**RE: 64<sup>th</sup> Street Subdivision**  
**4221 64<sup>th</sup> Street NW**  
**Grading and Drainage Plans**  
**Engineer's Stamp Date: 08/06/2025**  
**Hydrology File: F10D067**  
**Case # HYDR-2025-00294**

Based upon the information provided in your submittal received 08/14/2025, the Grading & Drainage Plans **are not approved** for Grading Permit or Building Permit. The following comments need to be addressed for the approval of the above referenced project.

DESIGNED BY: CDS
DRAWN BY: CDS
CHECKED BY: CDS
DATE: 11/08/2024

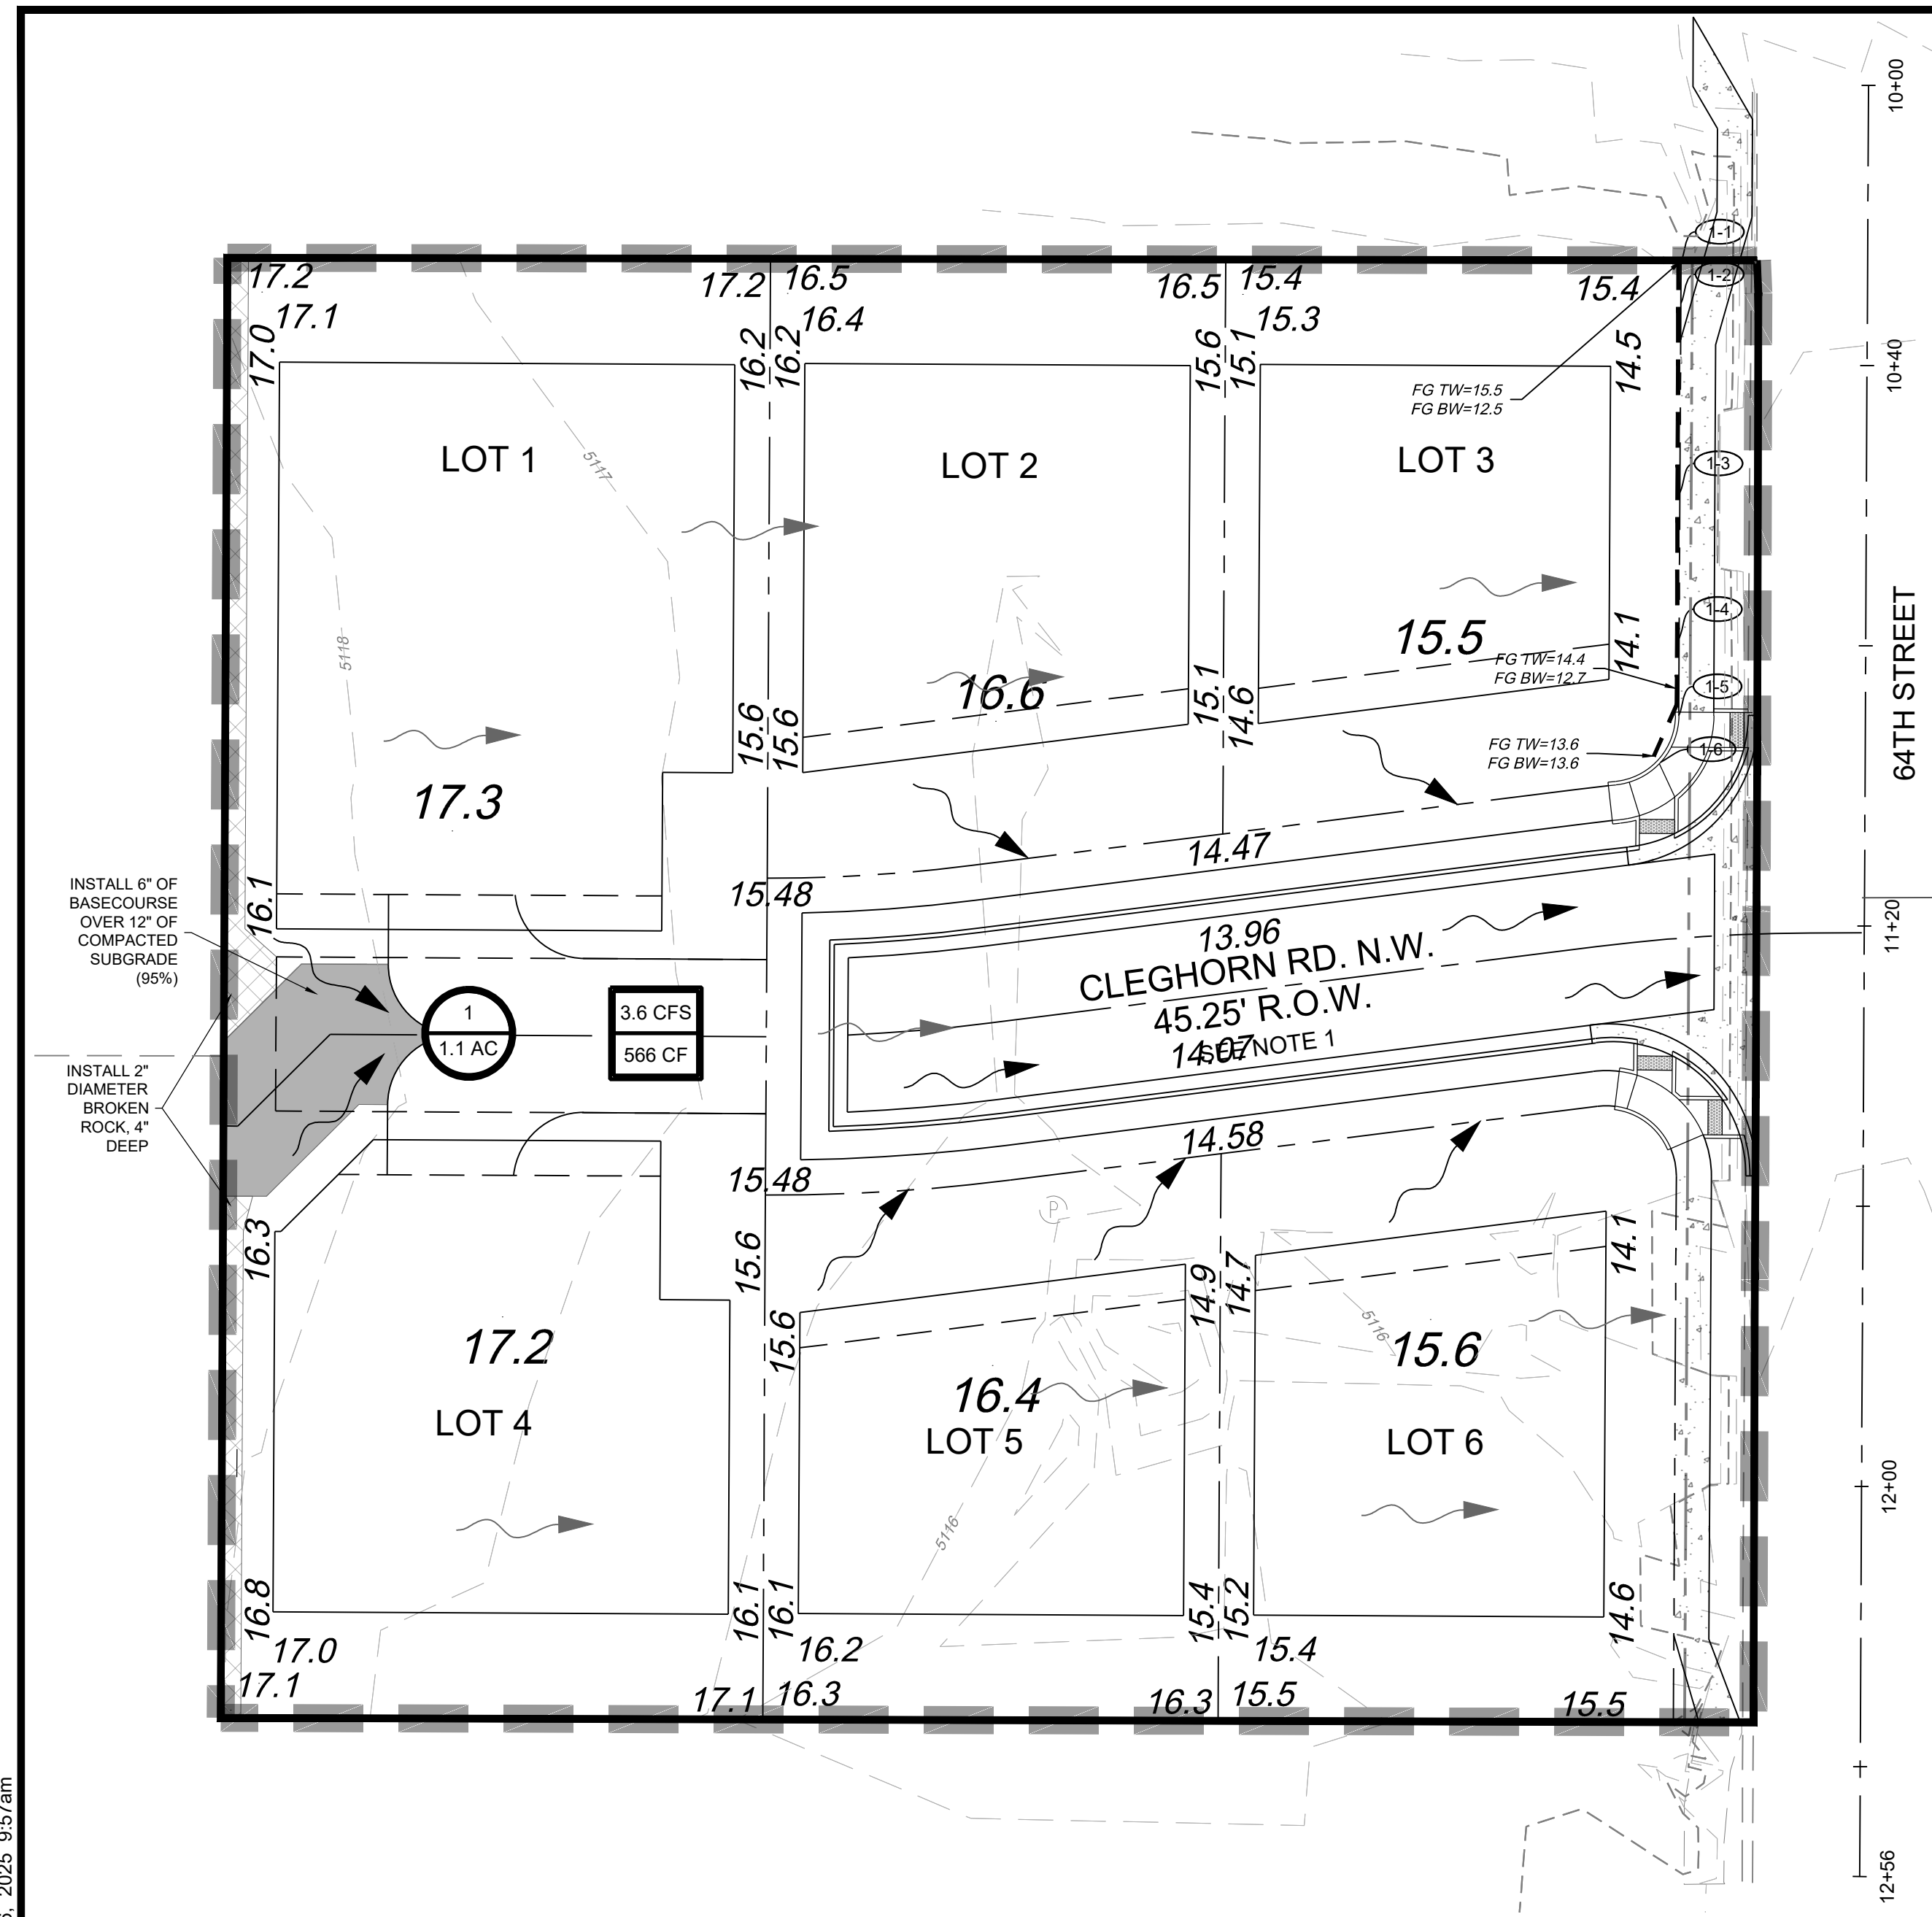
3. Identify internal retaining walls to be constructed by the developer (prior to Pad Cert) and those to be deferred to homebuilder. Any wall retaining 2 feet or more will need to be constructed by the developer (i.e prior to Pad Cert); less than 2 feet retained can be deferred to homebuilder.
4. CG-101 – Remove Grading Note #3 – Retaining walls less than 2 feet are not shown. See comment #2.
5. CG-101 – Grading Note #2 – The Retaining Wall Elevation Table is missing from this sheet.
6. There appears to be a retaining wall on 64<sup>th</sup> east of Lot 3. Provide the existing and proposed grades on both sides of the proposed retaining wall.

DESIGN REVIEW COMMITTEE	CITY ENGINEER APPROVAL	ZONE MAP NO.	F-10-Z
		CITY PROJECT NO.	####
		SHEET NO.	CG-101

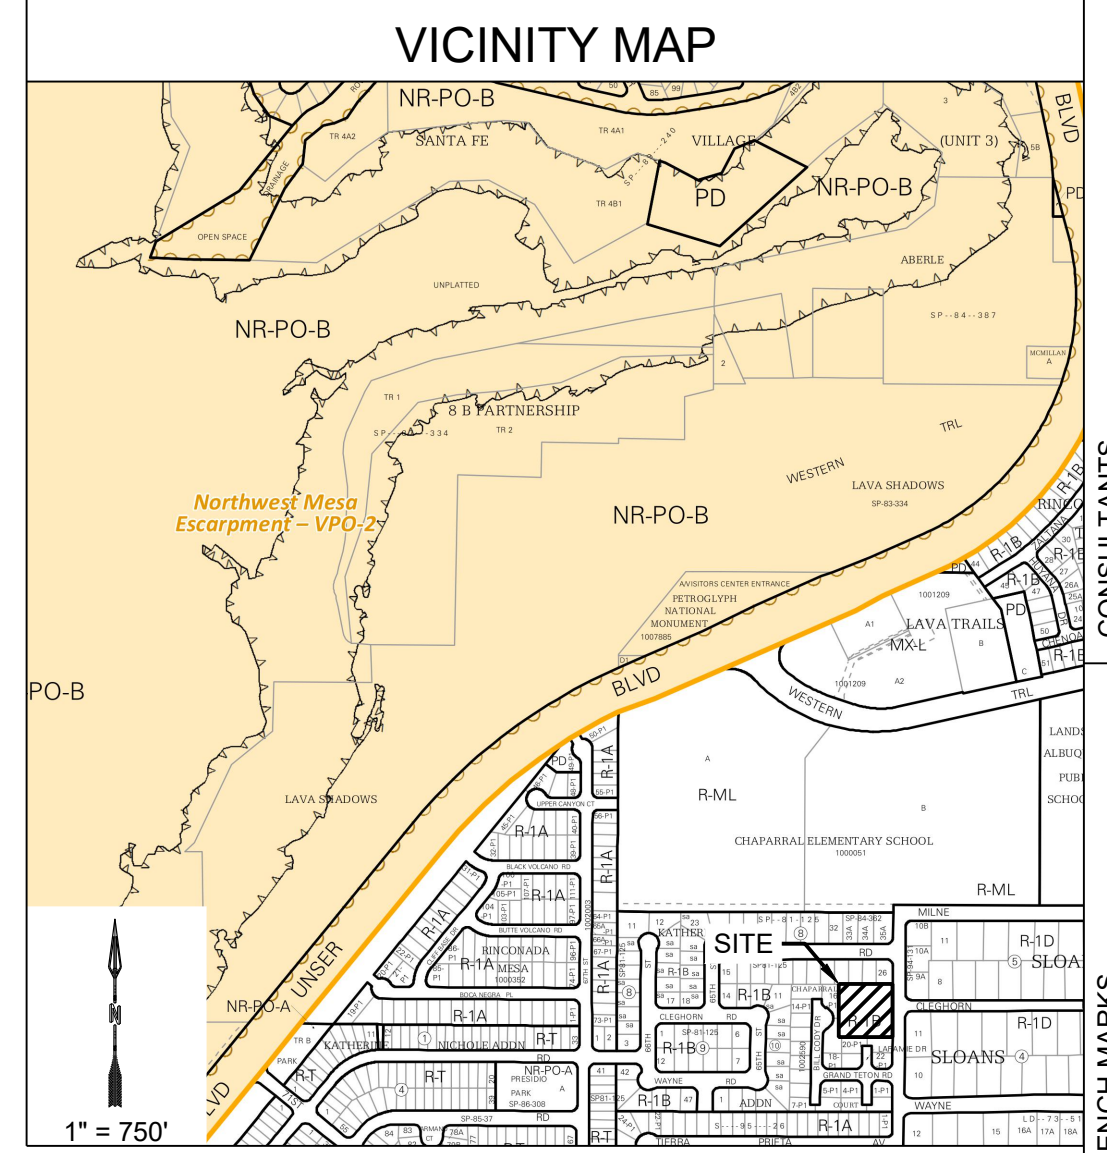
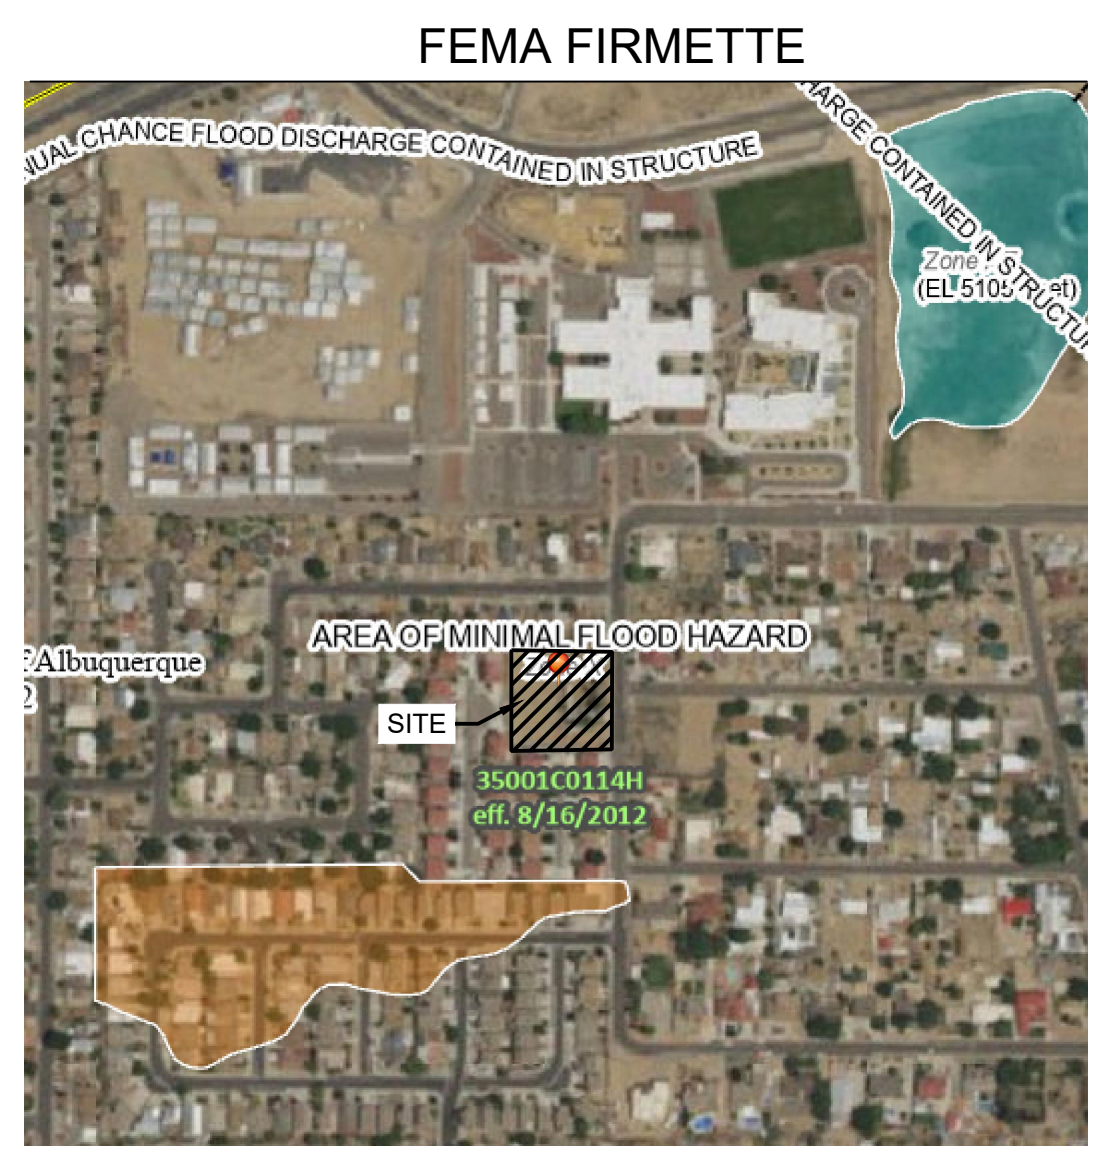
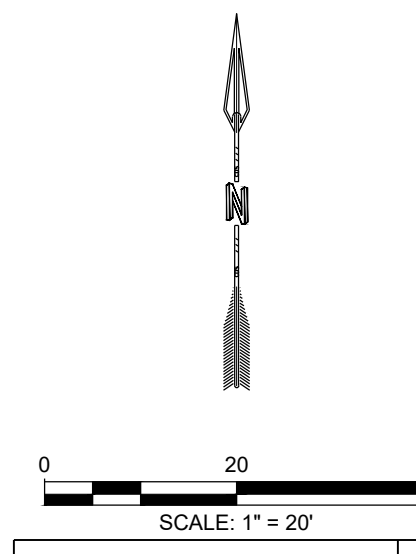
1. Remove the 30% NOT FOR CONSTRUCTION over the Engineer's Stamp on sheet CG-101.

PROPERTY LINE SECTIONS

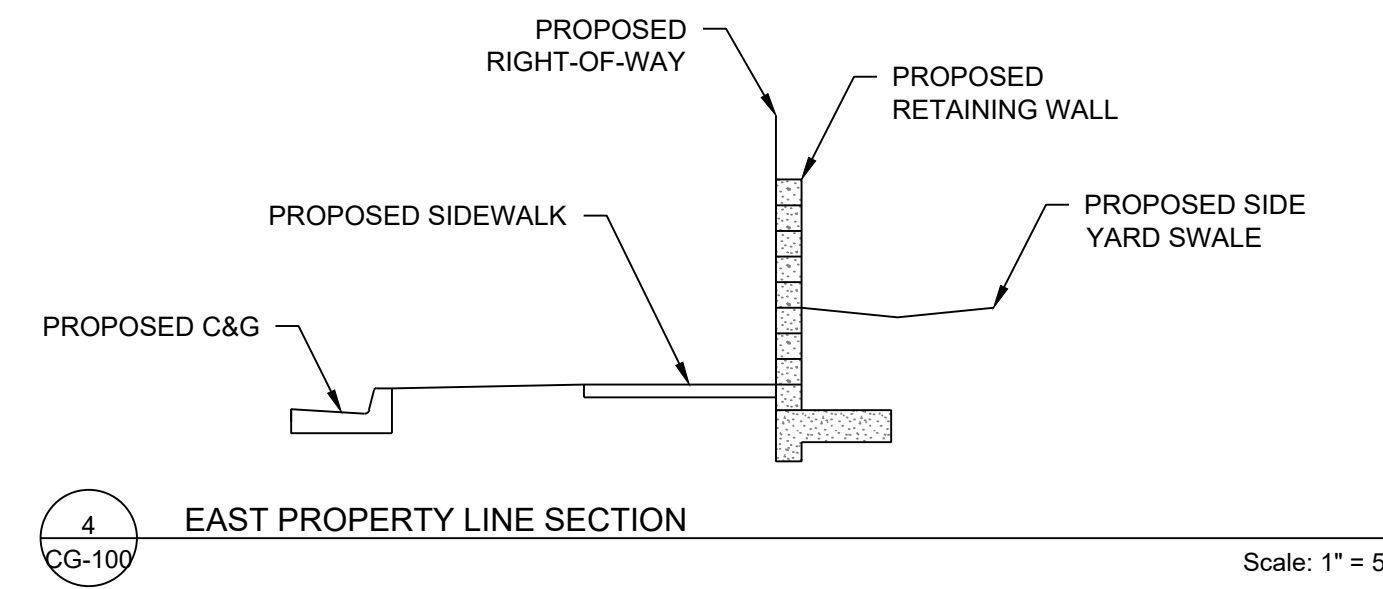
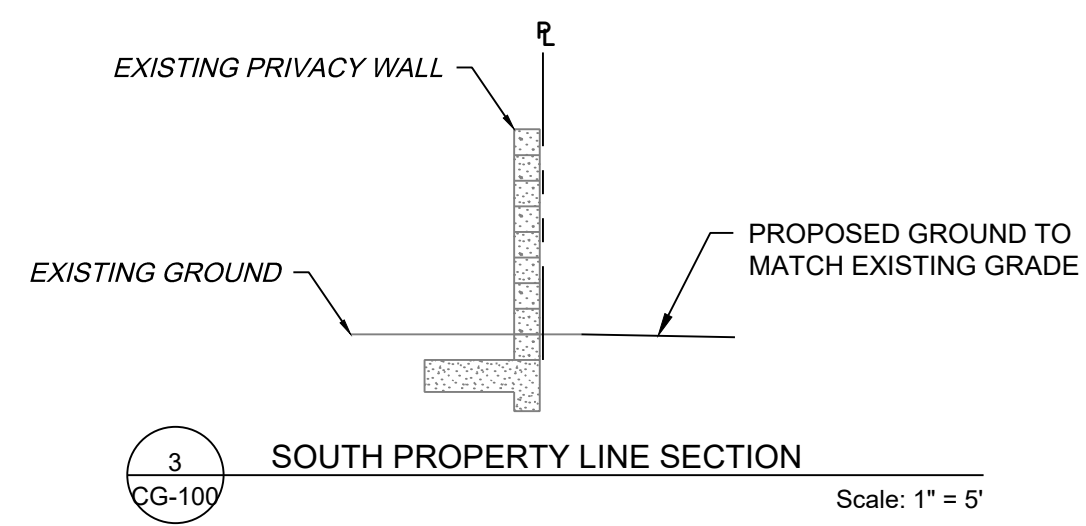
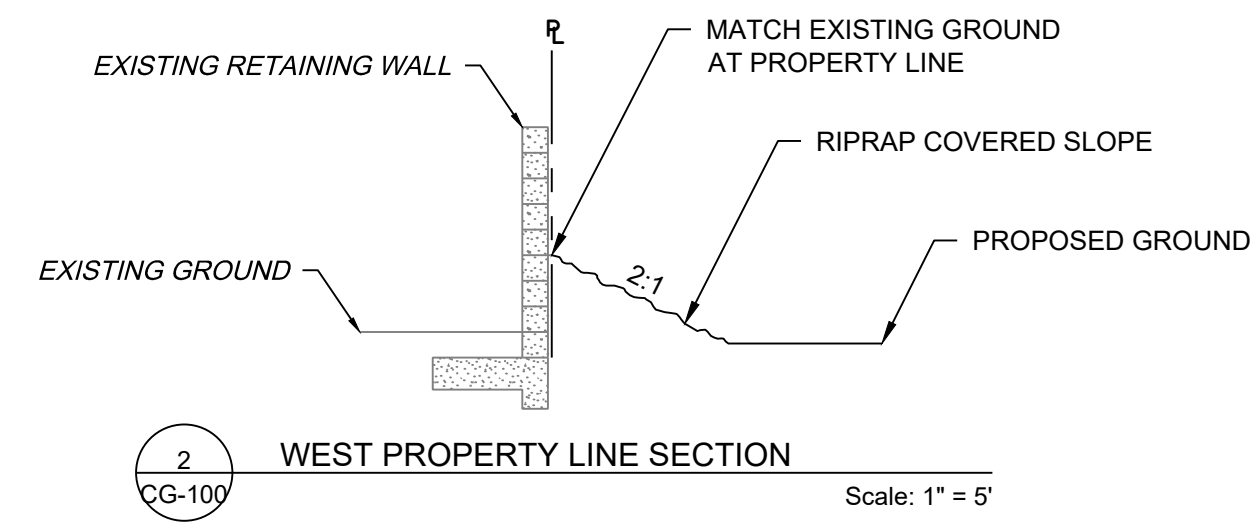
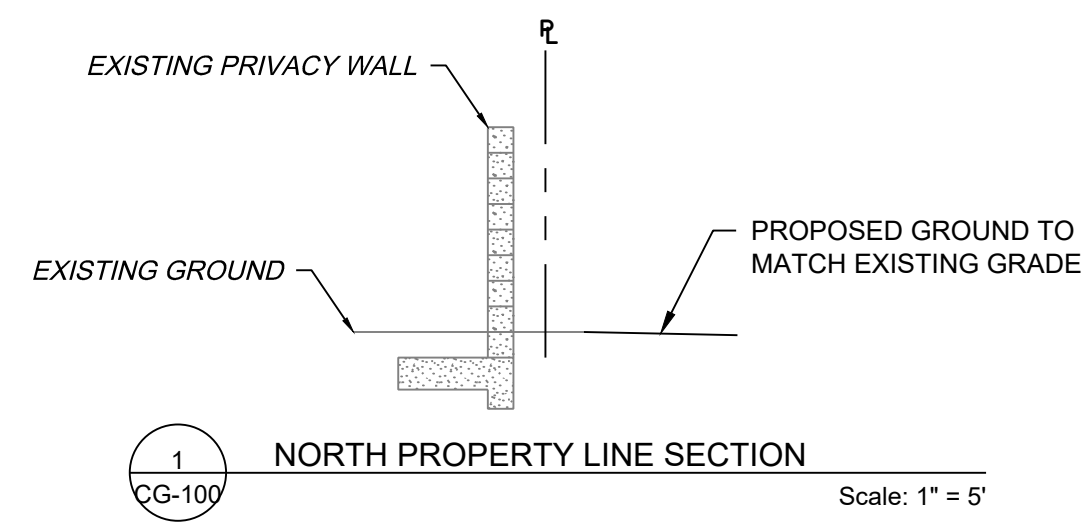
7. Provide sections through all external boundaries showing proposed retaining walls, garden walls, property/ROW lines, existing and proposed grades. In accordance with DPM Ch.22, section 5 part B, grading and wall construction near the property line may not endanger adjacent property or constrain its use.
8. Please provide the legal description of the property.
9. Payment in Lieu (Amount =  $566CF \times \$6/CF = \$3,396$ , per sheet CG-100) of onsite management of the SWQV must be made. Take three copies of the treasury deposit slip to the Treasury and then include one copy of the paid deposit slip when resubmitting.
